**Re: Modification Request for 7 Railway Street Chatswood (MP09_0154 MOD 1)
Council Reference S100002**

I refer to the notification of an application to modify the approval for a residential/commercial building at 7 Railway Street Chatswood (MP09_0154 MOD 1) lodged by JBA Planning Consultants on behalf of Mirvac Projects Pty Ltd.

LEVEL 38

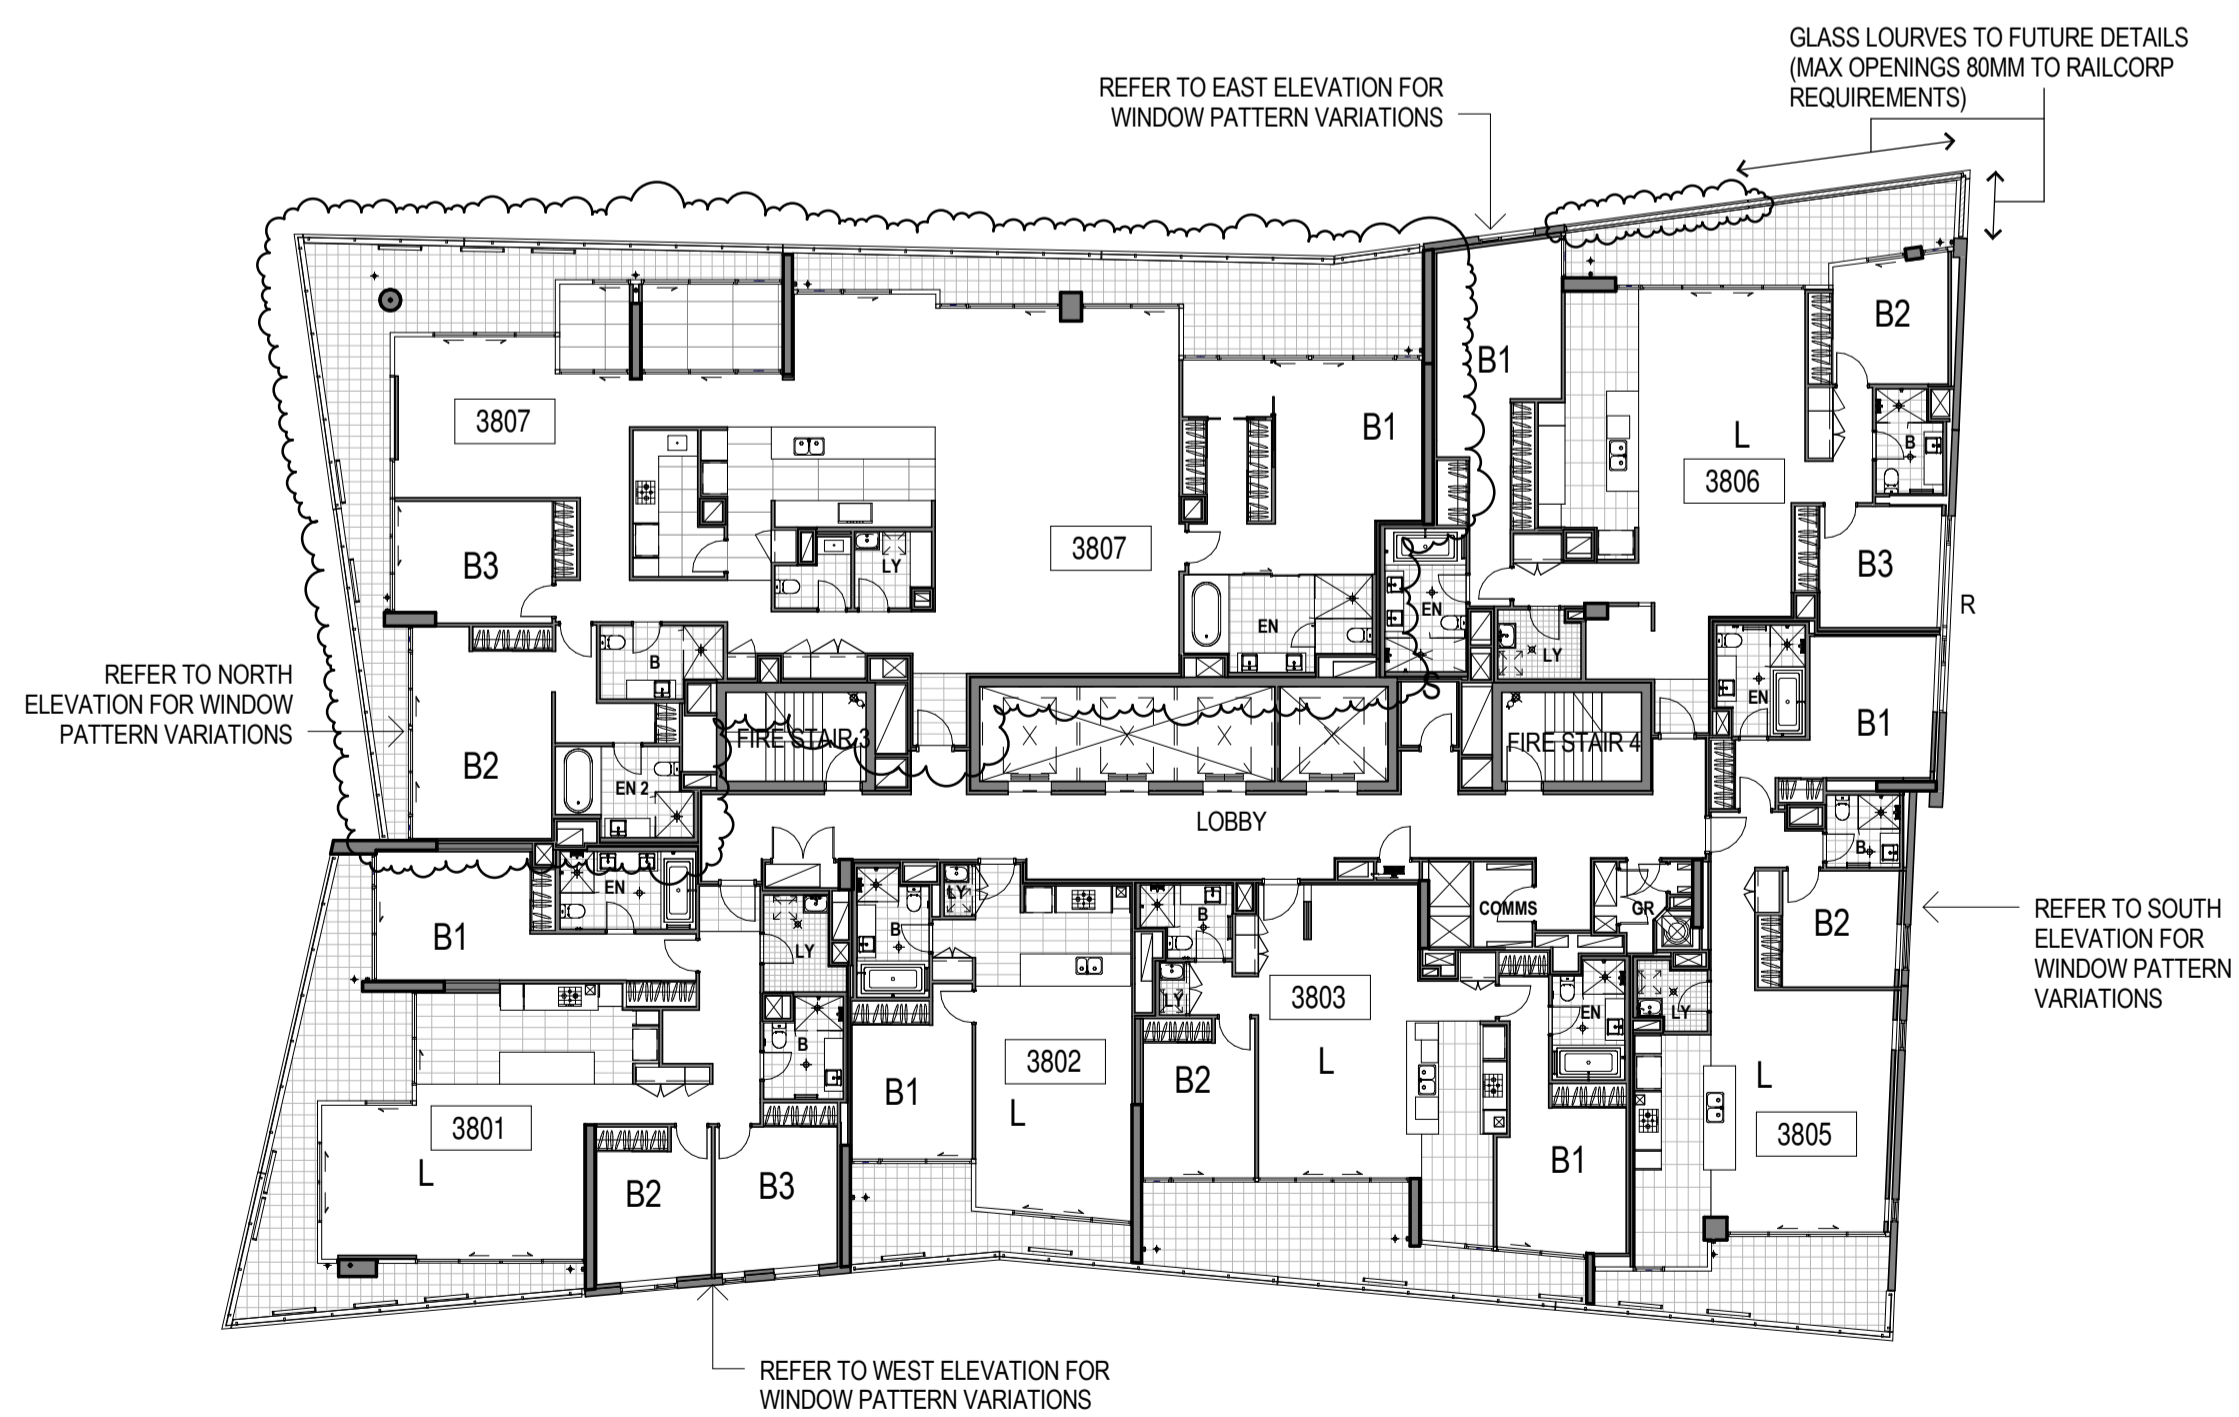
No objection is raised to the amalgamation of two units into one on Level 38.
